WEST SUSSEX COUNTY COUNCIL CONSULTATION

TO:	Arun District Council FAO:David Spring
FROM:	WSCC - Highways Authority
DATE:	17 February 2020
LOCATION:	51 Falkland Avenue Littlehampton BN17 6AB
SUBJECT:	LU/2/20/PL Conversion of house into 3 No. self contained flats. An amendment received on 12.02.2020.
DATE OF SITE VISIT:	n/a
RECOMMENDATION:	Advice
S106 CONTRIBUTION TOTAL:	n/a

Block Plan

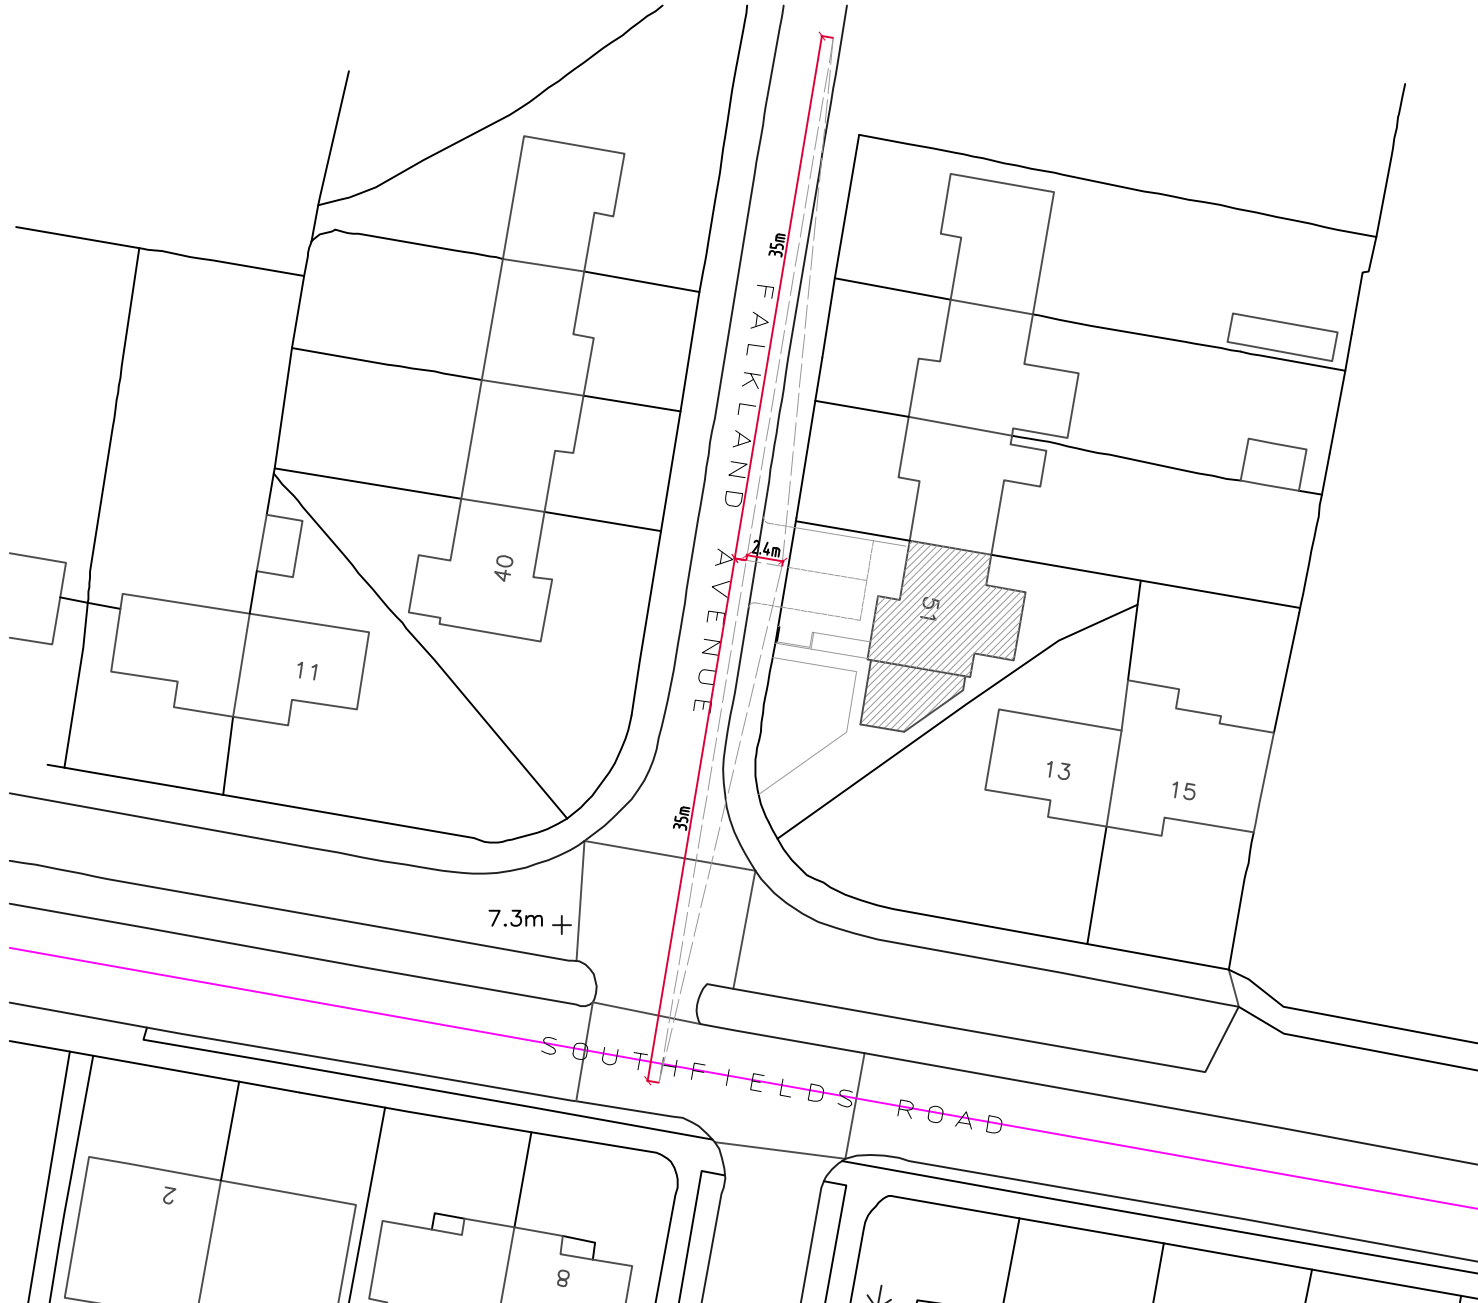
The proposed access has been amended and follows the advice provided by the WSCC Highway Area Manager to provide shared VCO measuring circa 6m. Any access works must be constructed under a licence obtained by WSCC Highways to a specification agreed with them.

The revised block plan demonstrates visibility splays at the proposed access using a 2.4m 'X' distance. However, having measured this I note that the 'X' distance is approximately 1.7m from the nearside edge of the carriageway. Therefore, the shown maximum available visibility splays of 35m in each direction may not be achievable. The LPA may wish to consider the potential visibility restrictions when deciding this application.
